18-003
Nyton House
Nyton Rd, Westergate, Chichester, West Sussex,
PO20 3UL

Detailed Planning Application Design & Access Statement

Document Status	LISTED BUILDING CONSENT APPLICATION
Revision	P3
Author	JL/JK
Checked by	CP
Issue date	April 2019

Proposed Elevations

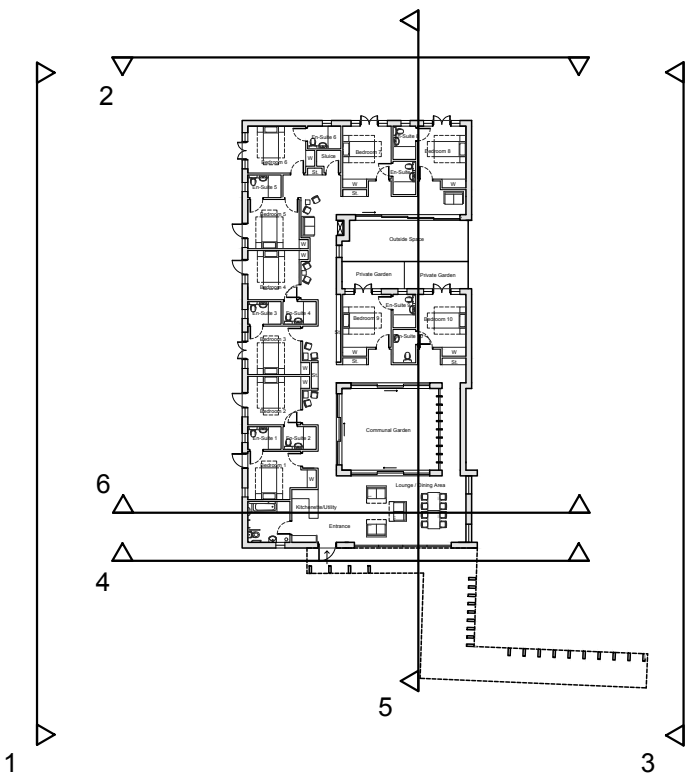
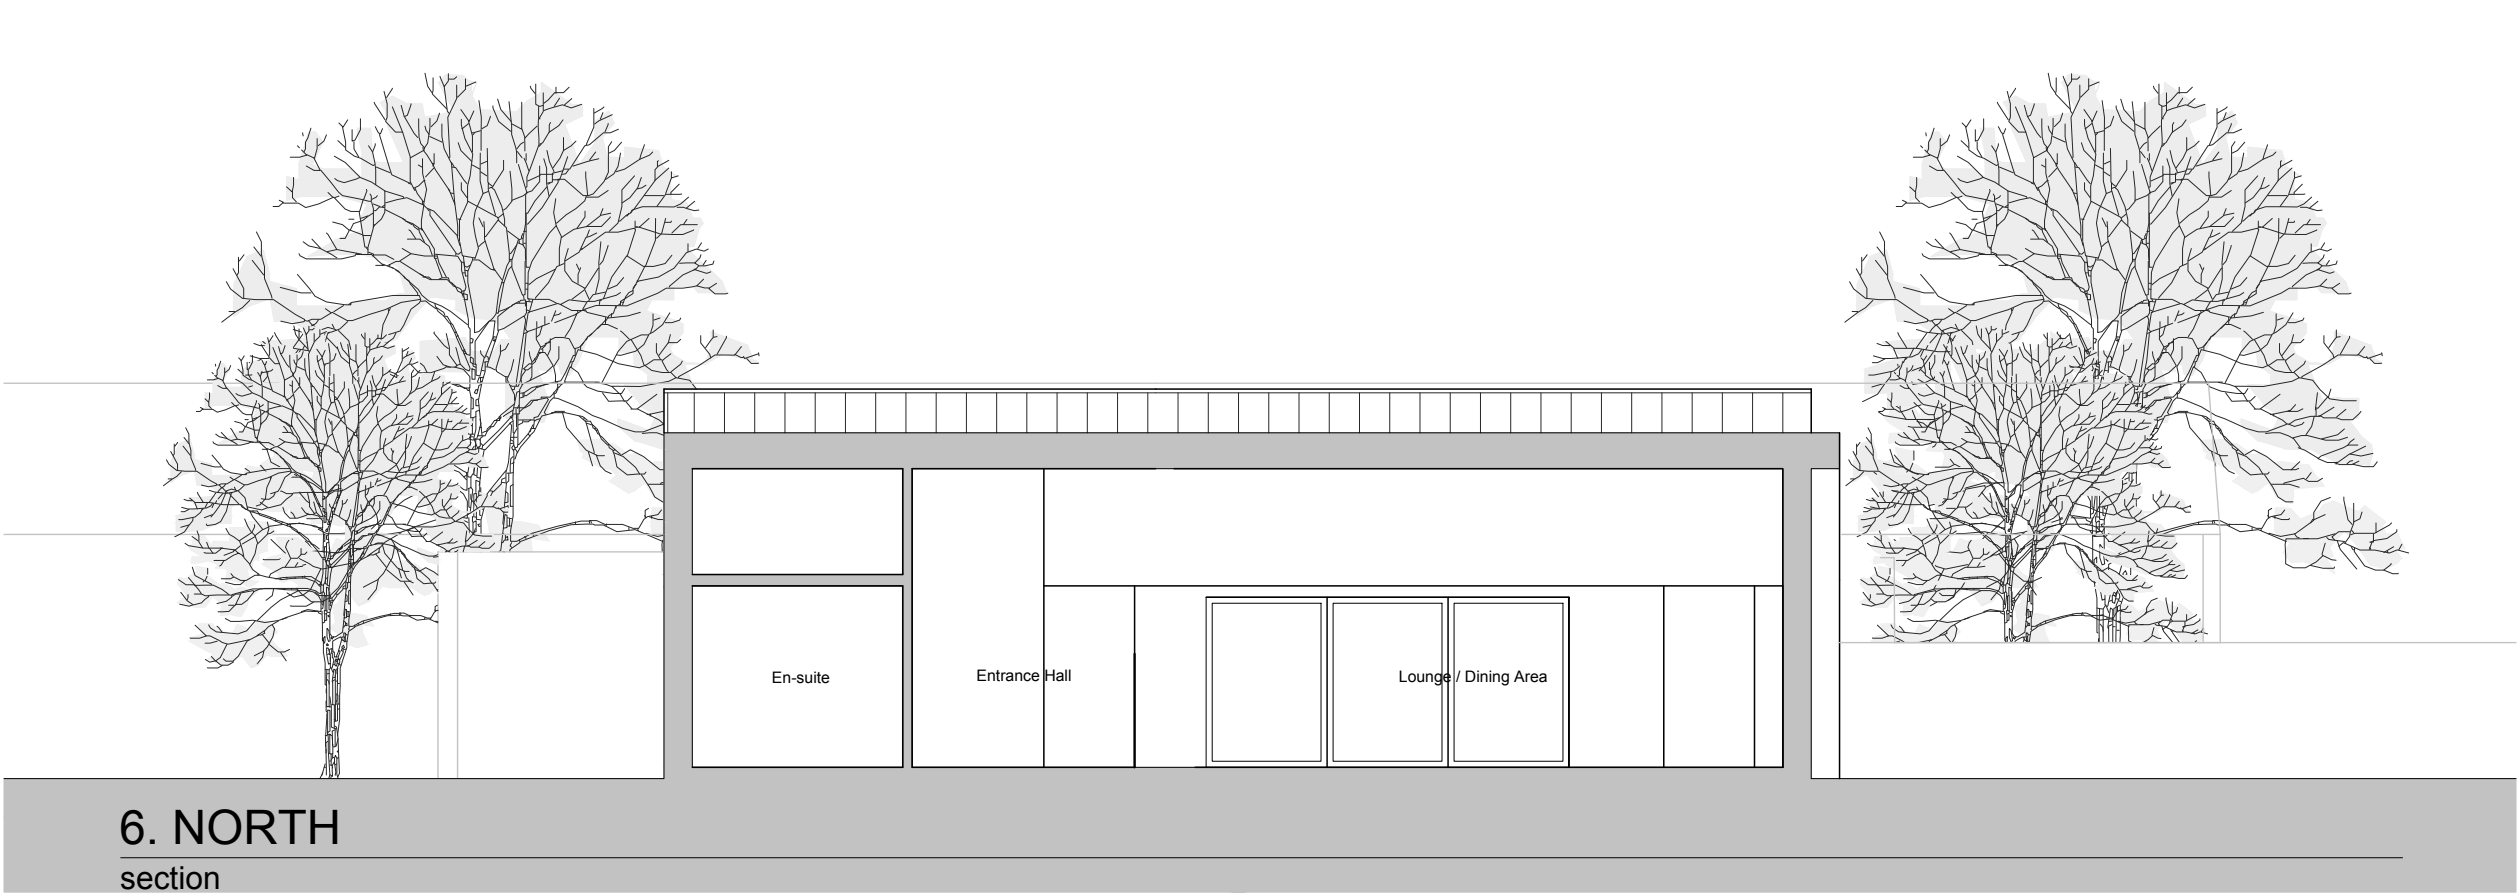
- It is noted that the argument for the design approach is to reflect the surrounding agricultural buildings. Such an approach is understood. As mentioned above, the closest buildings are the now converted former estate buildings which are constructed from brick.*

As the wing is located some distance from the main house the building form has been designed to reflect the adjacent agricultural buildings, however the material palette is sympathetic to the original house and nearby estate buildings, and closely matched brickwork will help to blend the new development between the two influences.
